EROSION AND STORMWATER QUALITY CONTROL PERMIT (ESQCP) EL PASO COUNTY APPLICATION AND PERMIT

PPR2419

EC1

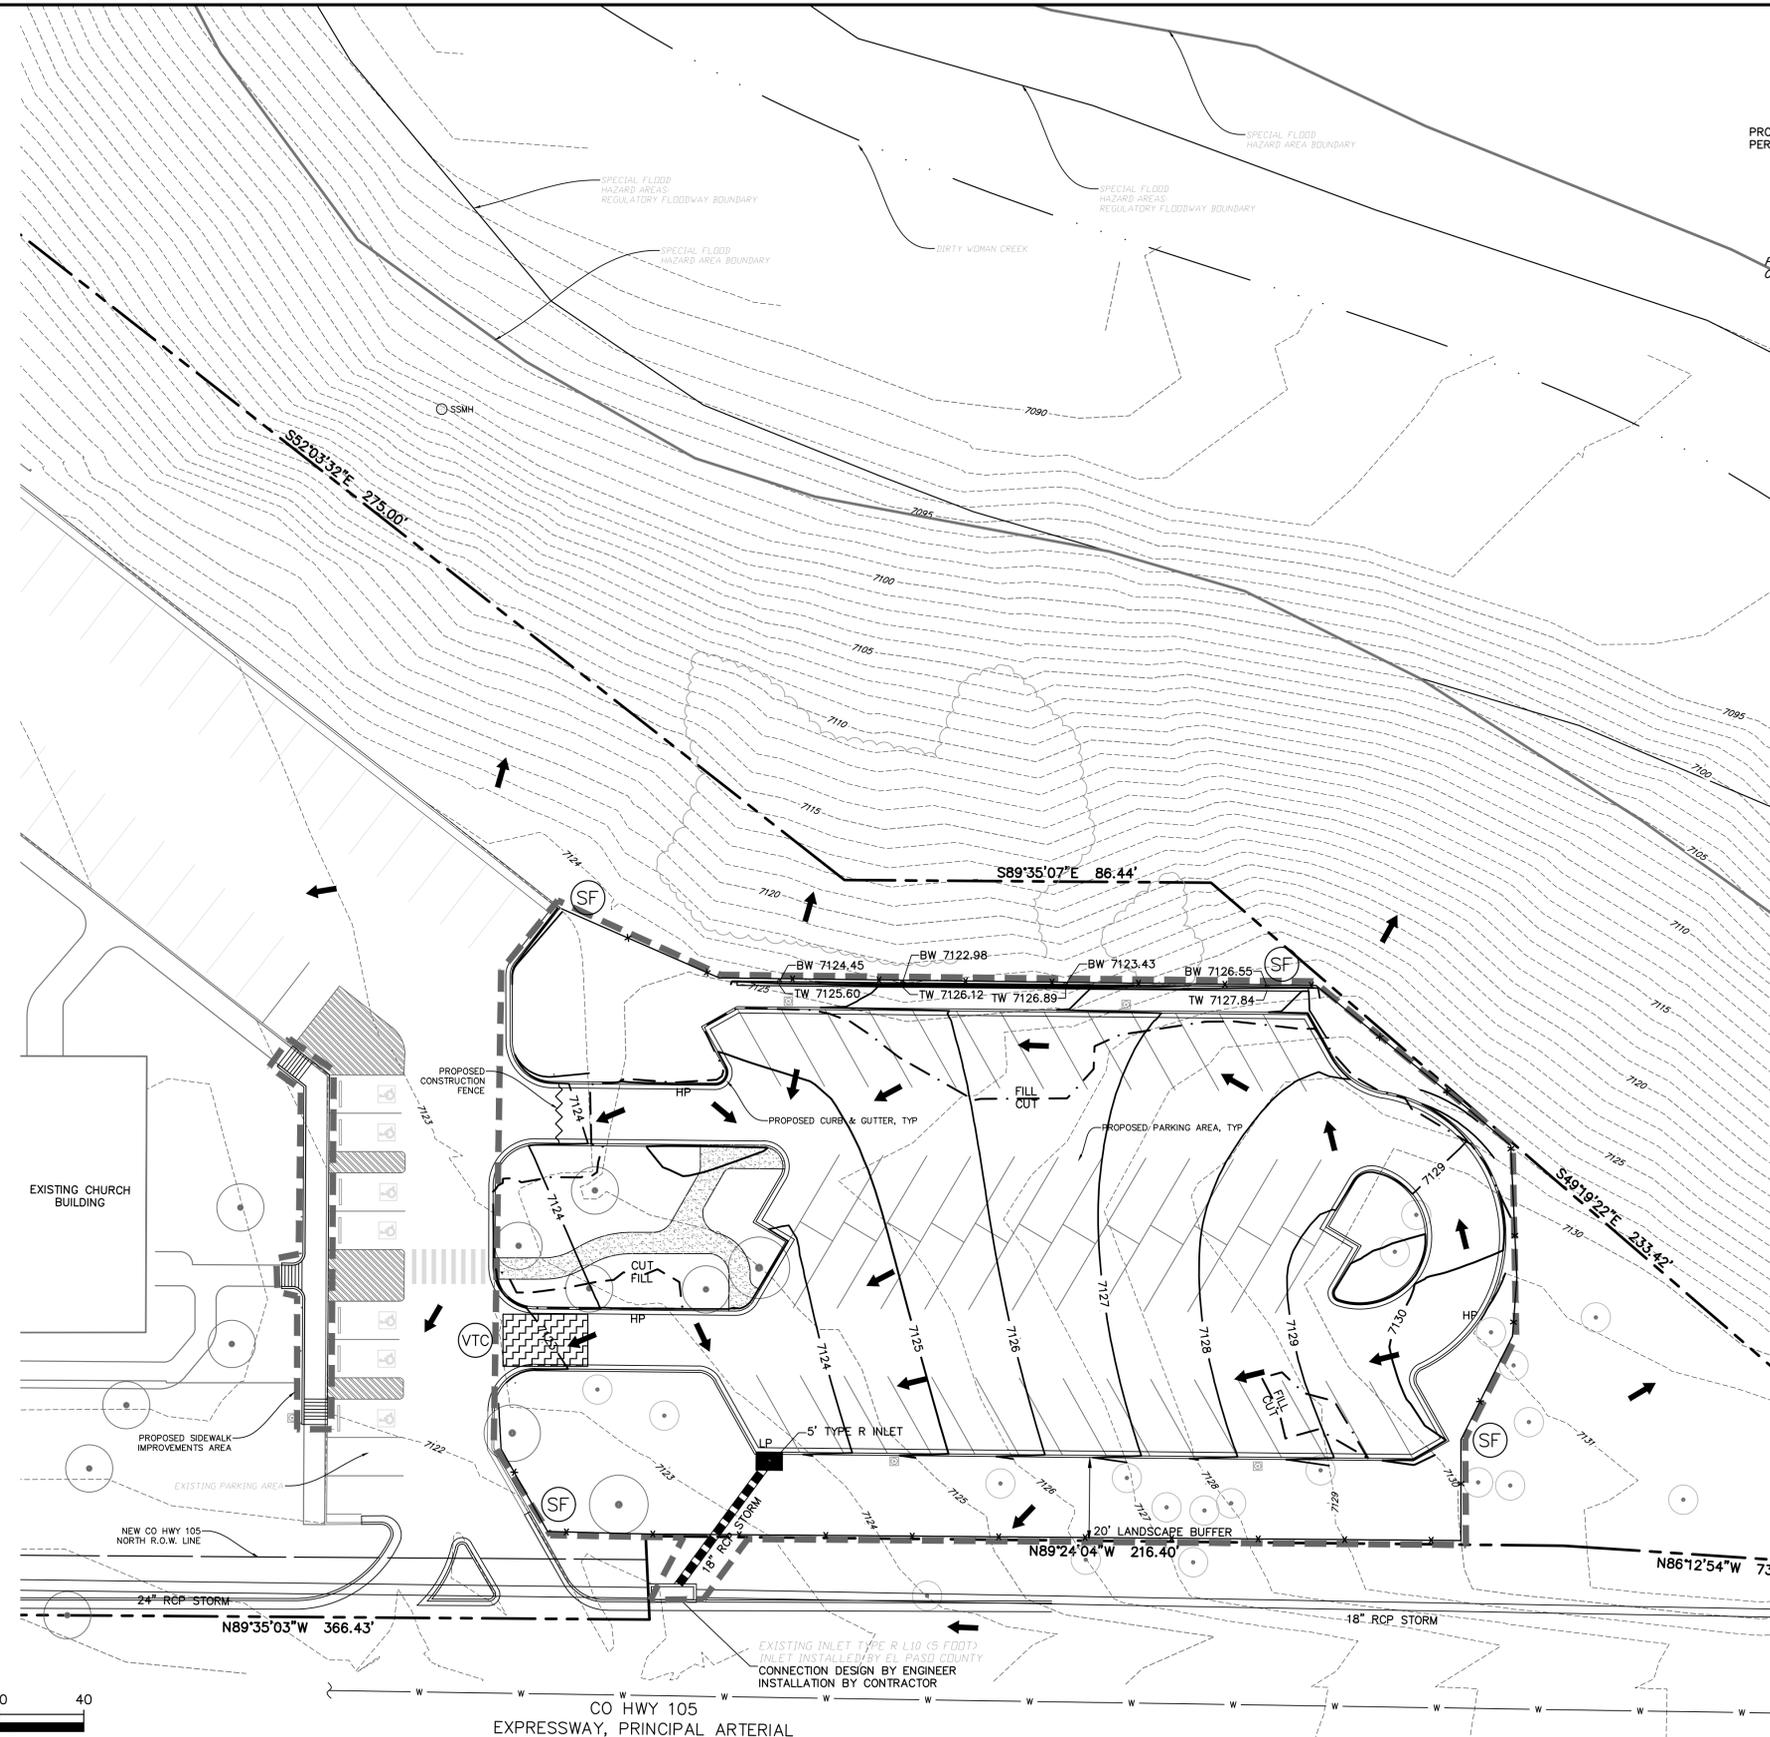
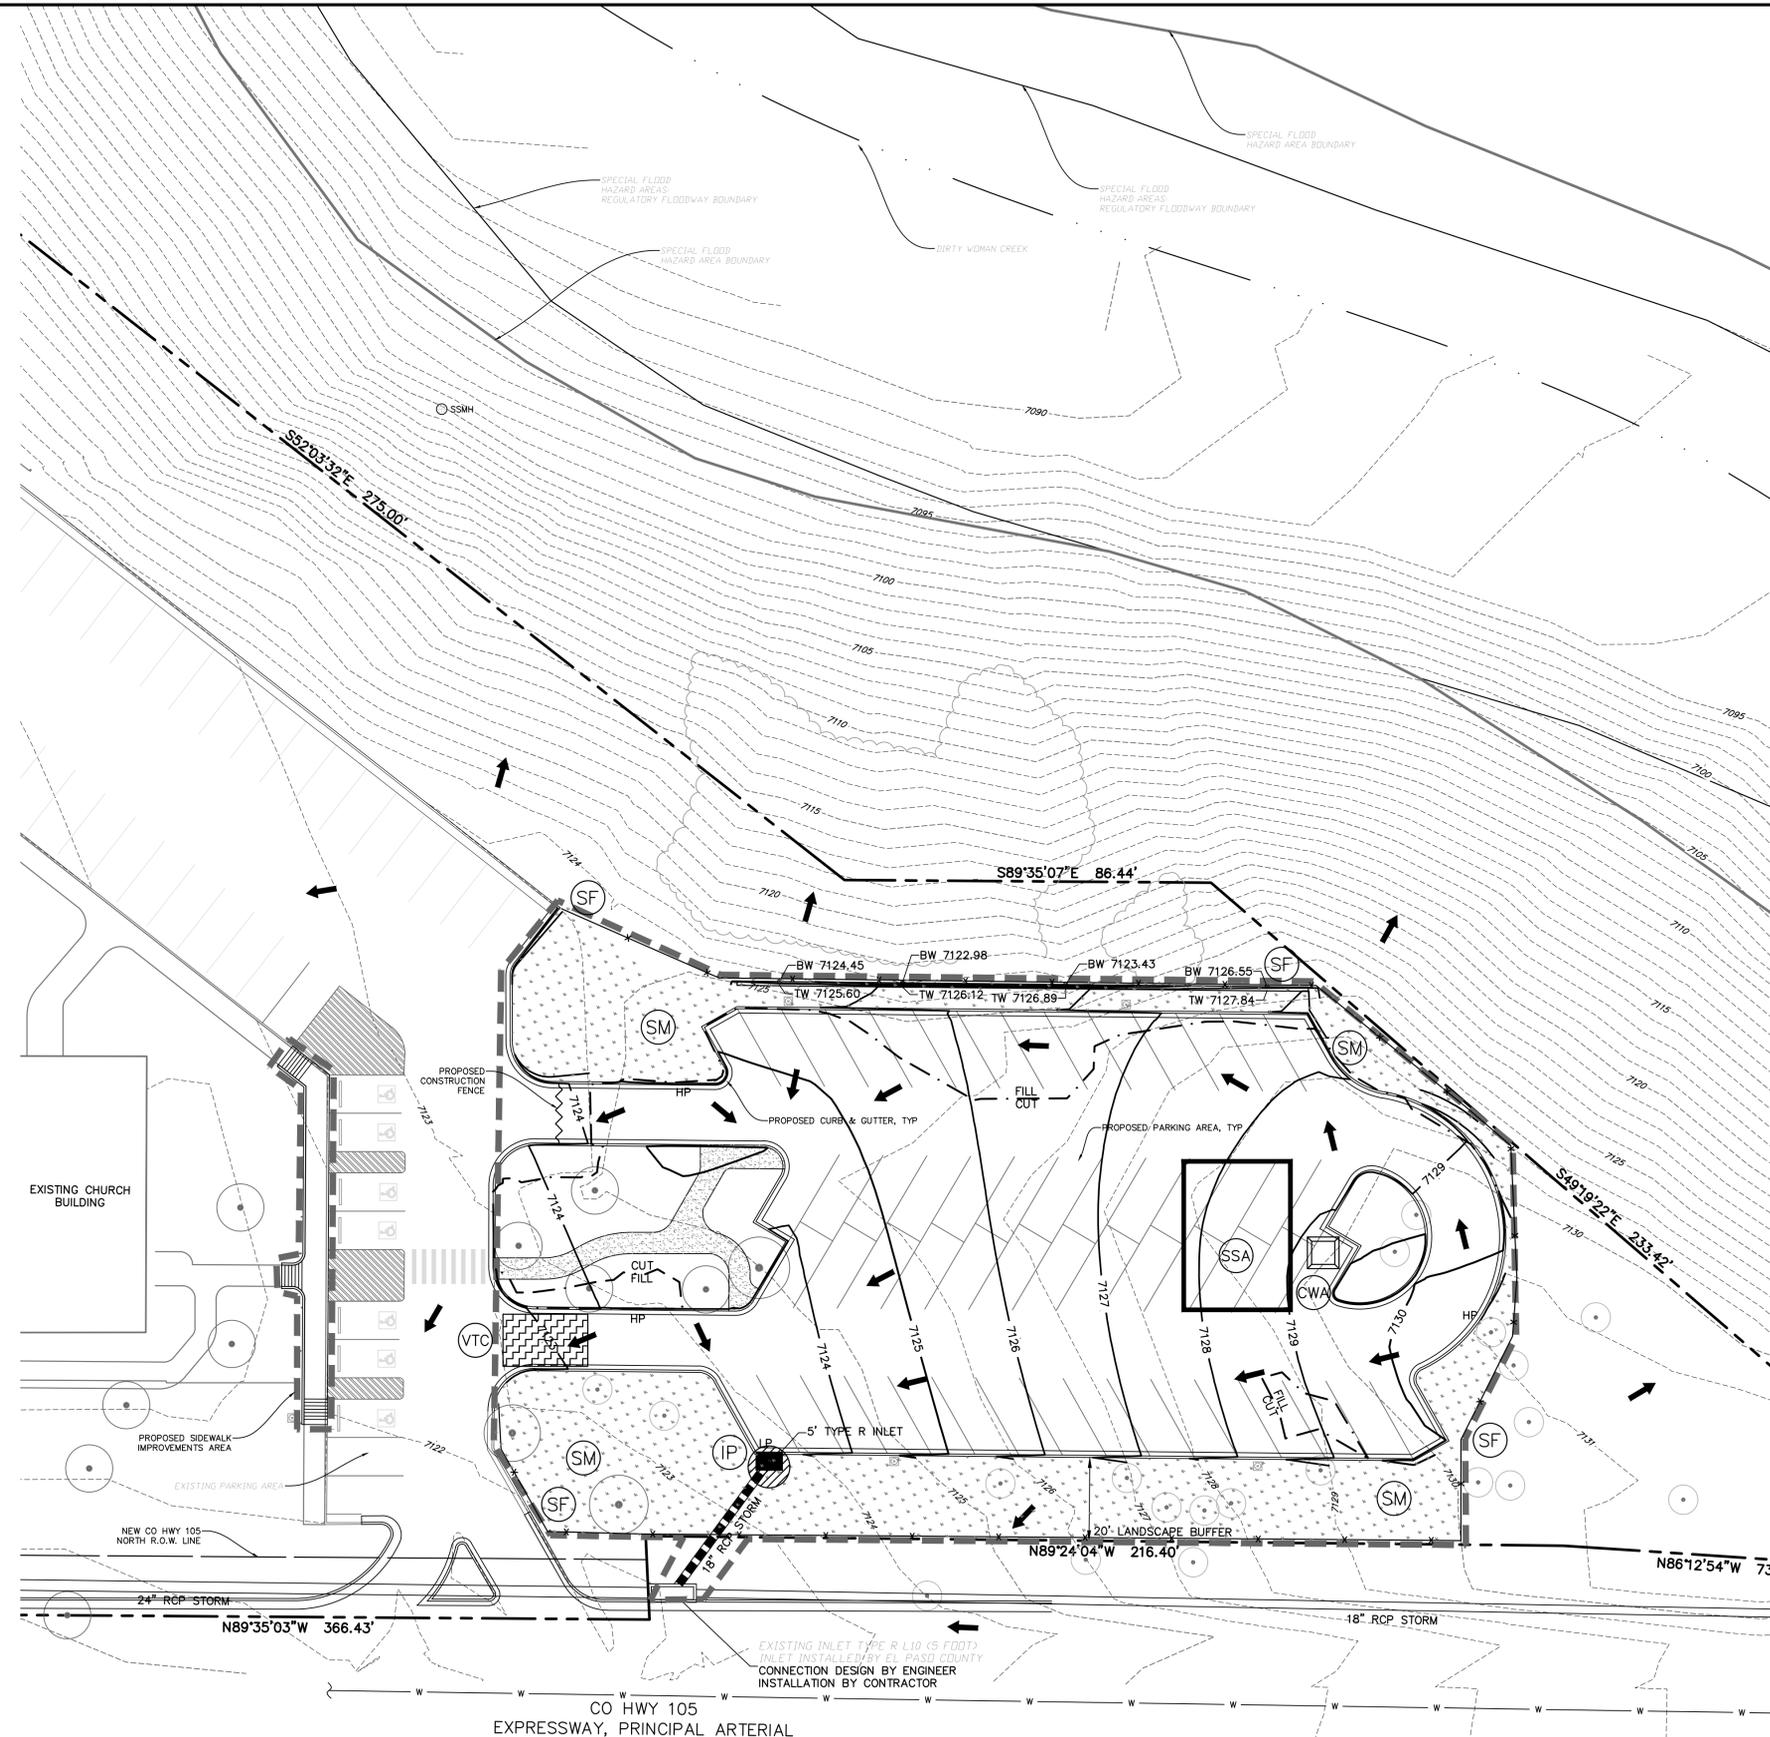
The plans show less than 1 ac. Verify and update.
